**From:** [Jeremy Larson](#)  
**To:** [Chace Pedersen](#)  
**Subject:** RE: ACU-23-00003 Atlas - Notice of Application  
**Date:** Tuesday, August 22, 2023 8:08:57 AM

Please find KC CDS Building Department comments below for the documentation provided in ACU-23-00003.

SHEET TITLE:
SITE PLAN

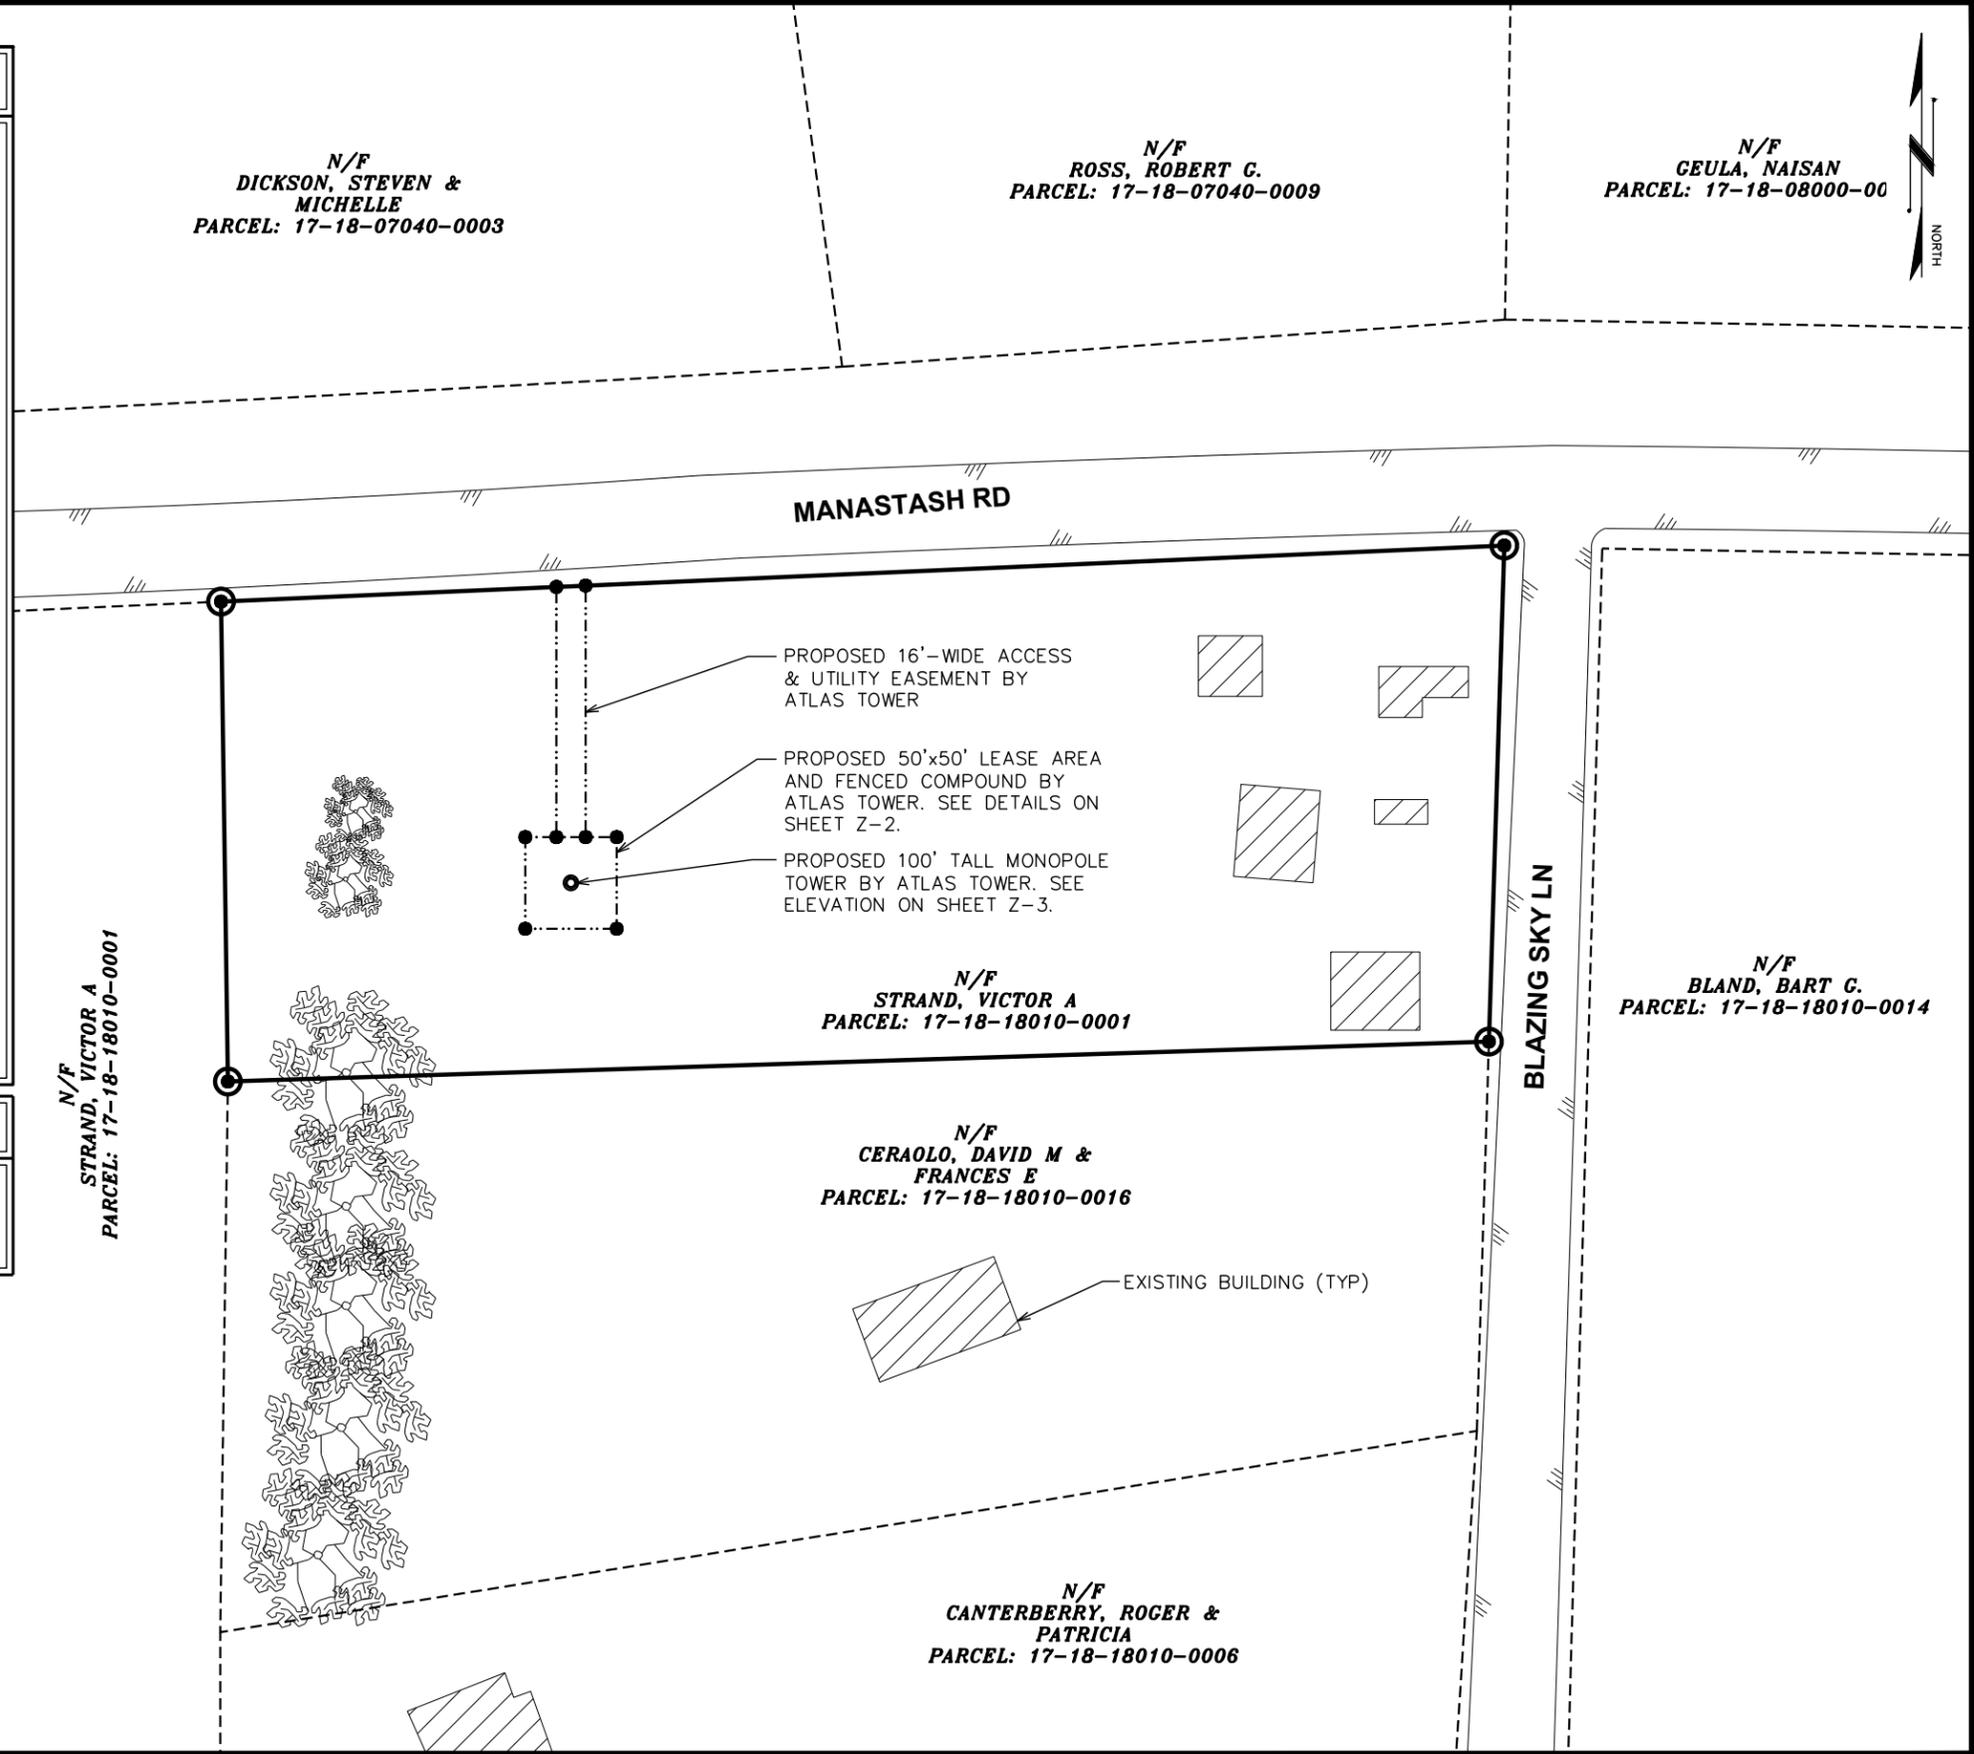
A building permit is required for the antenna. If the fence is over seven feet, a building permit will be required for it as well. The antenna permit documentation will need to include Washington State approved stamped engineer plans and supporting calculations for the footing, attachment to the footing, and the overall structure. The antenna needs to be a minimum of 1.2 times the height away from the property line.
